Report of the Head of Planning & Enforcement Services

Address 4 HAROLD AVENUE HAYES

Development: Single storey side/rear extension, conversion of roof space to habitable use to include a rear dormer, 3 front rooflights and conversion of roof from hip to gable ends and single storey detached outbuilding to rear for use as store involving demolition of existing detached garage to rear (Application for a Certificate of Lawful Development for a Proposed Development)

LBH Ref Nos: 67940/APP/2011/1760

CLIENT:	MR. M. KHURSHED						
PROJECT:	4 HAROLD AVENUE HAYES						
TITLE:	DESIGN PROPOSAL PLANS & ELEVATIONS		DRG NO: 1604 2				
DATE:	JULY 2011	SCALE:	1:50 1:100 AT A1				
DRAWN:			<table border="1"><tr><td></td><td></td><td></td><td></td></tr></table>

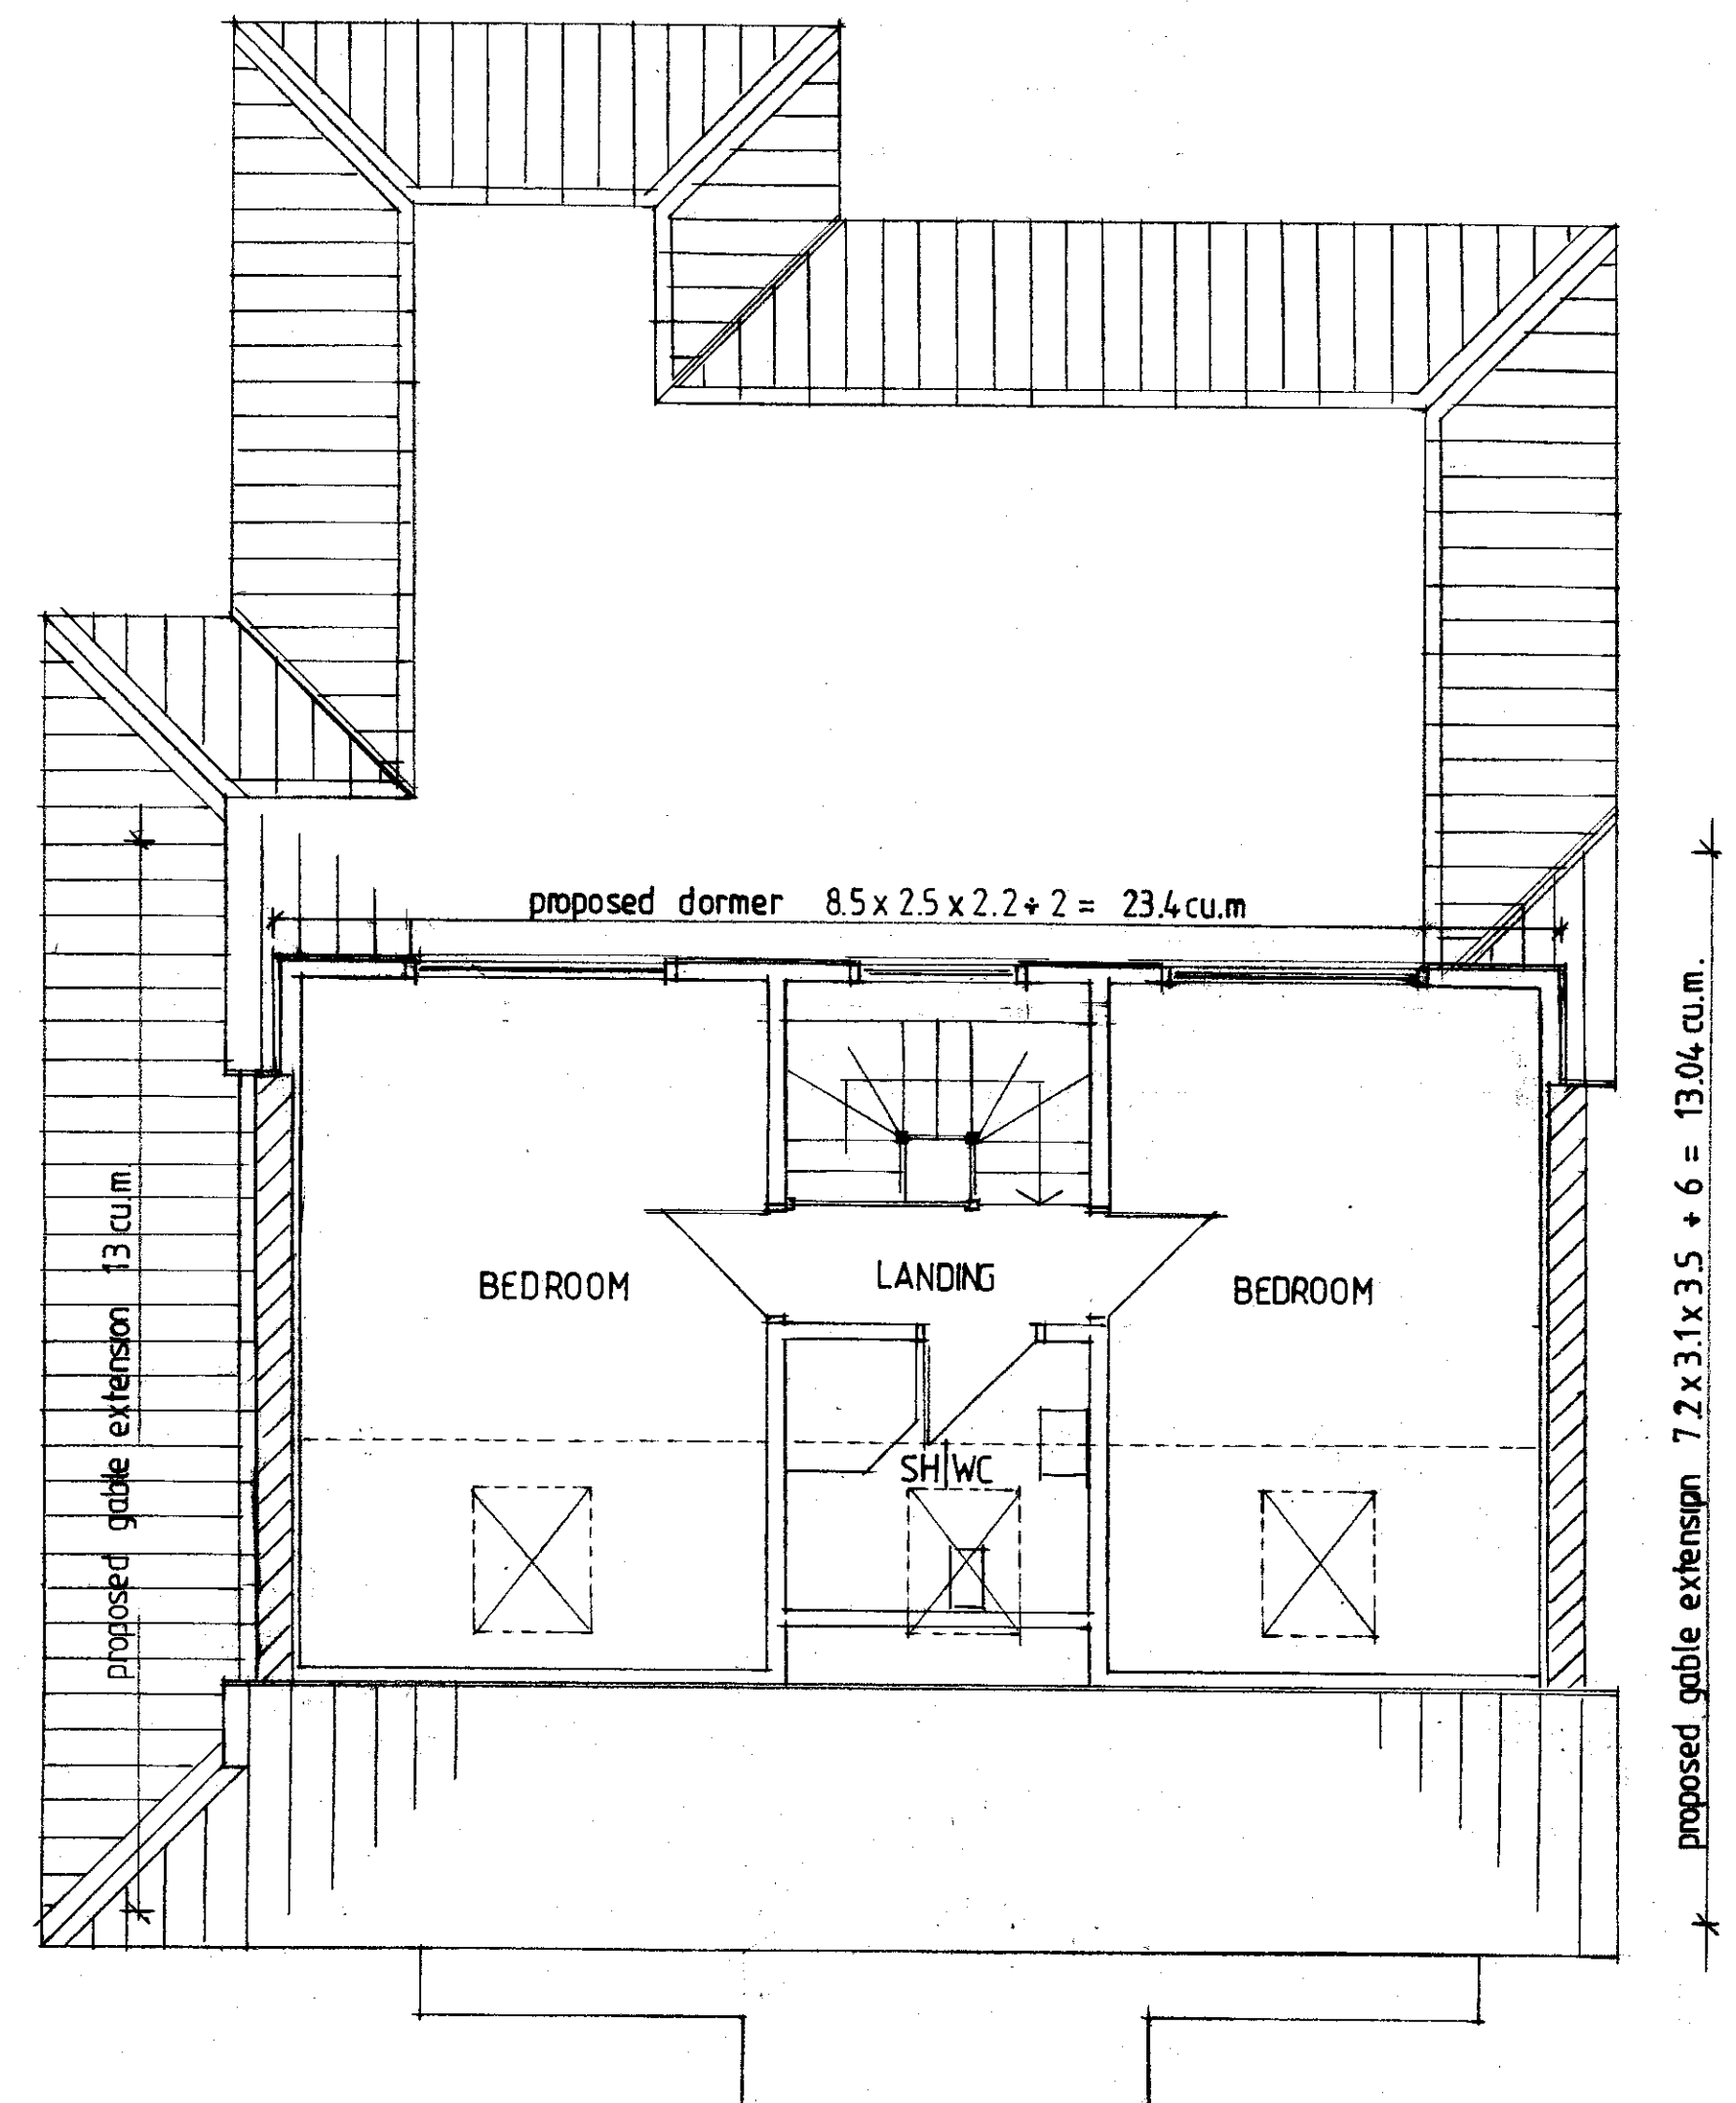
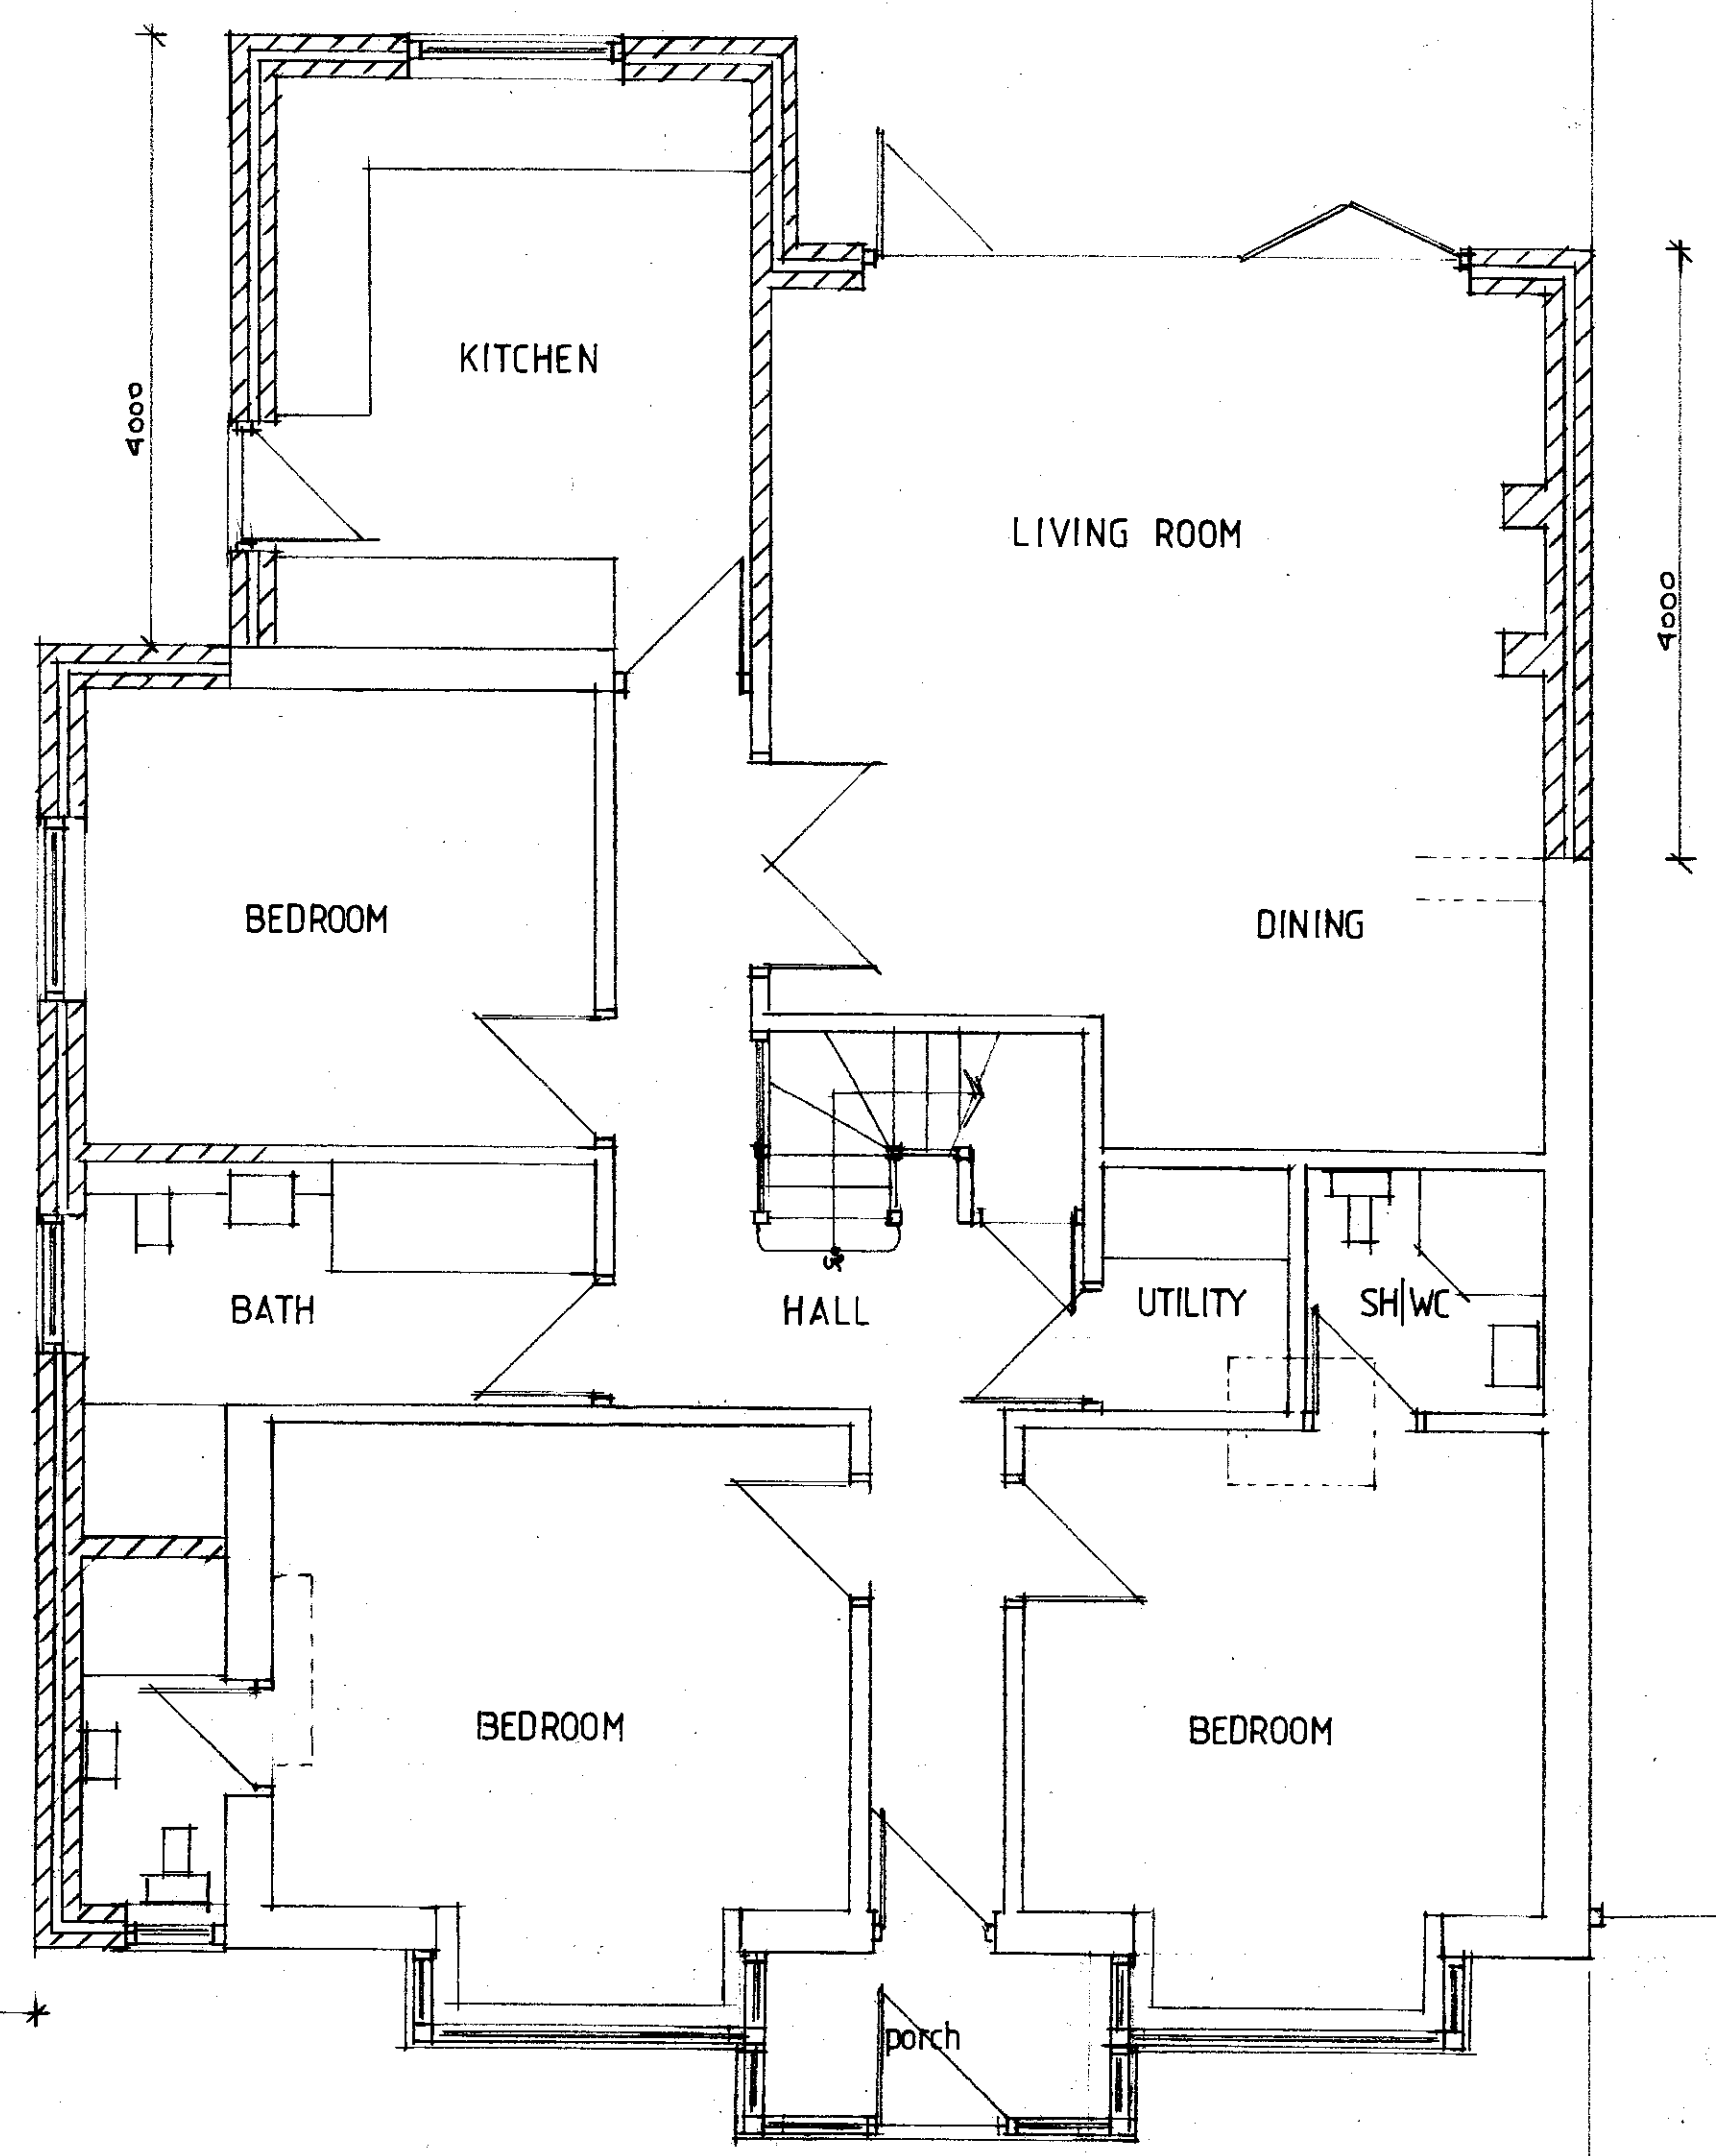
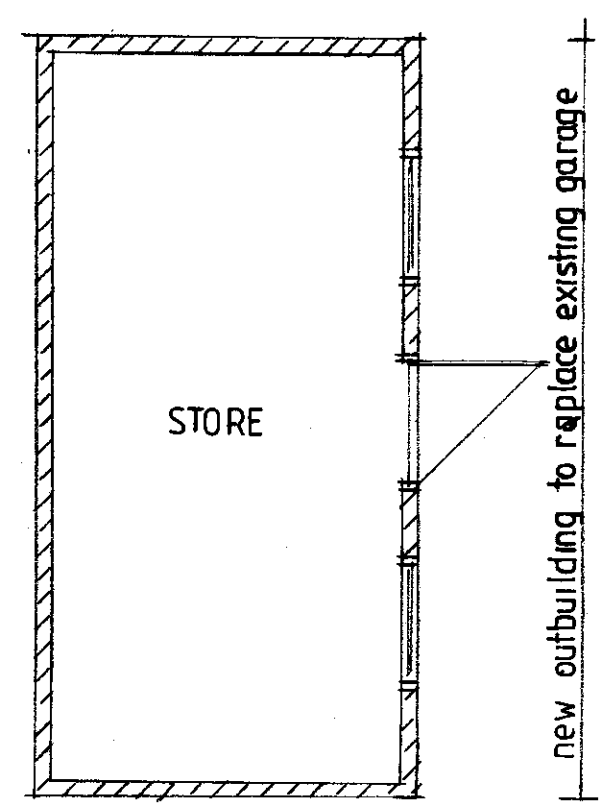
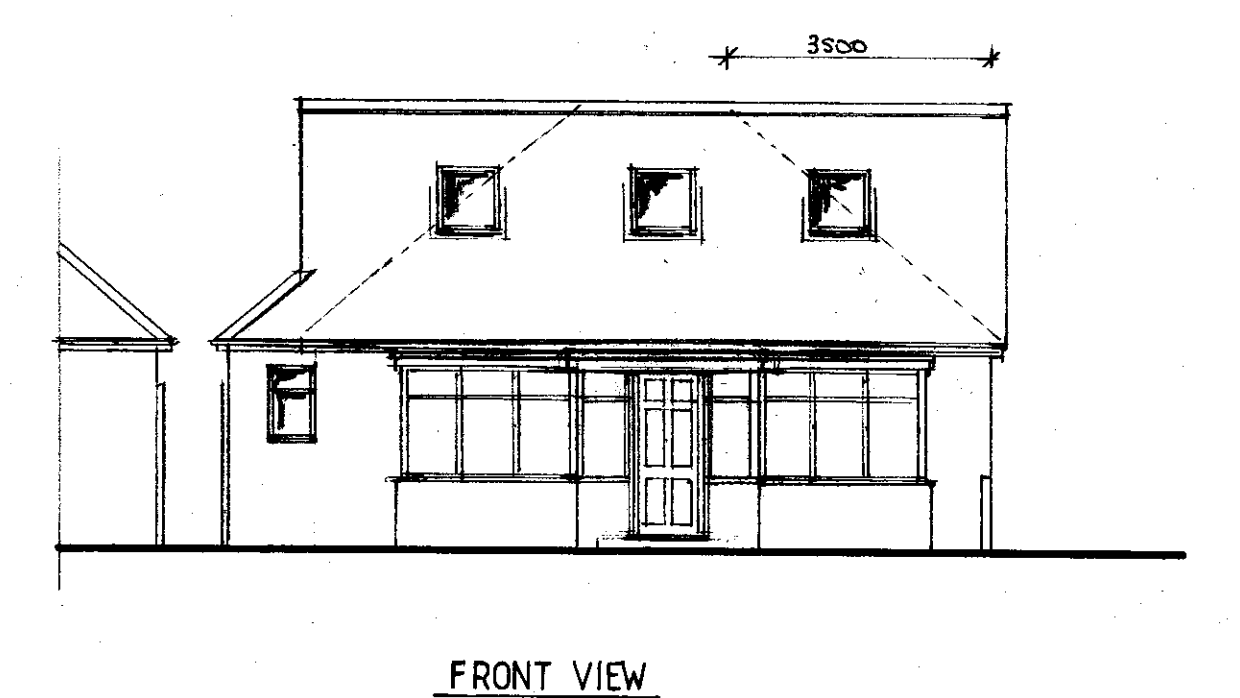
The plans indicate that the combined single storey rear extension, single storey side extension and replacement outbuilding would not cover more than 50% of the ground within the applicant site, excluding the ground area of the existing dwelling.

The proposed single storey rear extension would not extend beyond the rear wall of the original dwelling by 4 metres, would not be more than 4 metres in height and would have eaves below 3 metres in height within 2 metres of the boundary.

The proposed single storey side extension would not extend beyond a side elevation of the original dwelling by a width greater than half the width of the original house, would not be more than 4 metres in height and would have eaves below 3 metres in height within 2 metres of the boundary.

Plans indicate that the hip to gable roof alteration, three roof lights in the principal elevation and rear dormer would:

- i) Not exceed the height of the highest part of the roof,
- ii) Not extend beyond the plane of any existing roof slope which forms part of a principal elevation of the dwelling house and fronts a highway,
- iii) Not exceed the cubic content of the original roof space by more than 50 cubic metres,
- iv) Match the materials of the original dwelling and the rear dormer would be inset by 200mm from the eaves.
- v) Have roof lights less than 150mm above roof plane and lower than highest part of

The plans indicate that the proposed flat roofed outbuilding would not result in more than half the area of land around the original house being covered by additions and other buildings nor extend forwards of the principal elevation of the original dwelling-house. It would be a single storey building, no higher than 2.5 metres, not have an eaves height exceeding 2.5 metres, not be within the curtilage of a Listed Building and does not include the provision of a veranda, balcony or raised platform. The proposed development would therefore meet the criteria to be permitted development under Schedule 2, Part 1, Class E of the Town and Country Planning (General Permitted Development) Order 1995 (as amended).

$7.2\text{m (d)} \times 3.1\text{ (h)} \times 3.5\text{ (w)} = 78.12 / 6 = 13.02\text{ cubic metres per gable end}$

Total of two hip to gable conversions = $13.02 \times 2 = 26.04\text{ cubic metres}$

$8.5\text{m (w)} \times (2.5\text{m (d)} \times 2.2\text{ (h)}) = 46.75/2 = 23.375\text{ cubic metres}$

Total volume added $23.375 + 26.04 = 49.414\text{ cubic metres.}$

The measurements on the plans have been checked and the proposed hip to gable conversion and rear dormer would add less than 50 cubic metres to the original dwelling.
